# Memorandum

**To:** Planning Board

**Re:** Design Review 133 York Street- for January 2014 Hearing  
R6 Design Standards

1
A-202
NORTH ELEVATION
SCALE: 1/4"=1'-0"

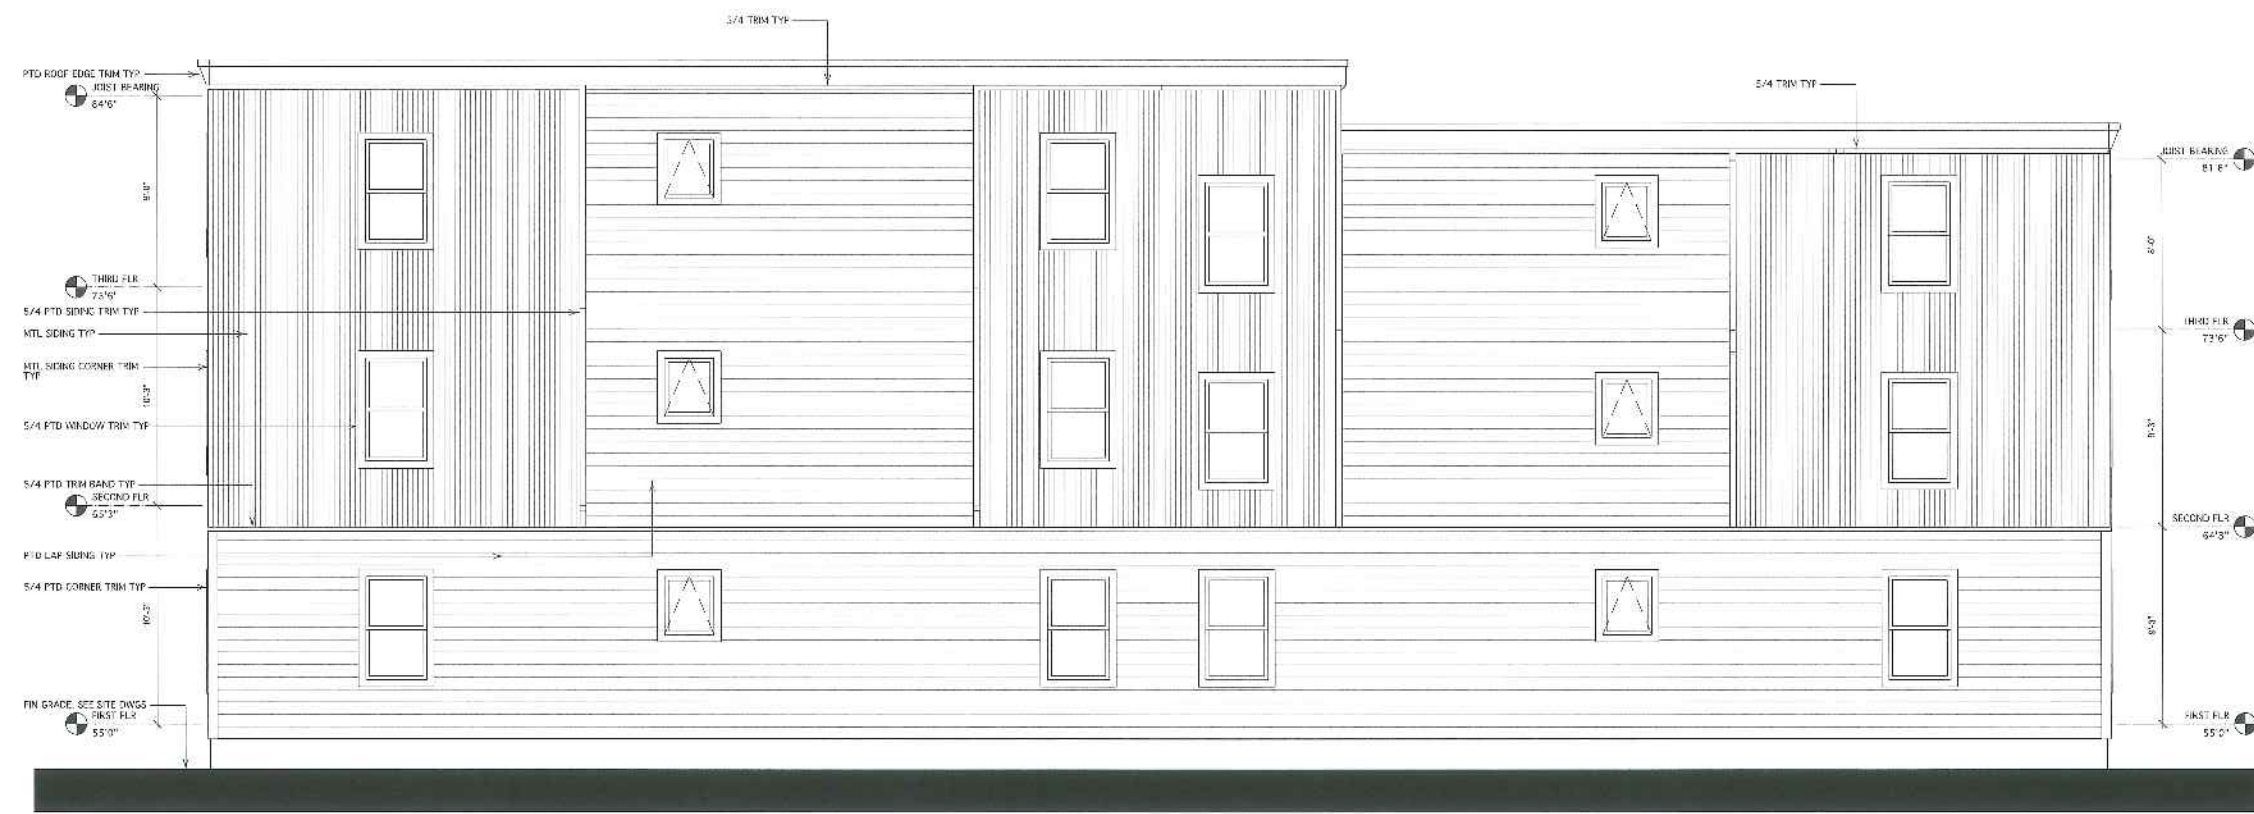
7. The rear elevation incorporates greater changes in texture and plane to break up the massing and overall more compatible with surrounding building styles though still lacking in a coherent “design approach”. The modification of the front elevation to remove the blue metal cladding makes the building design more harmonious and compatible, but reduces the prominence of the central front entrance section which faces York Street (which was an earlier design issue/comment).

8. Staff recommend the following revisions to reemphasize the entrance function and address the roof line which does not appear to be completely resolved in these final elevations:

- The tone of the entire central entrance section should be somewhat darker to contrast with the abutting material;
  - The overlarge and angled central cornice area should be simplified so it relates to the canopy over the entrance door and better ties into the roof line; and

- Lighting (downlighting) from underneath the entrance canopy should be added.
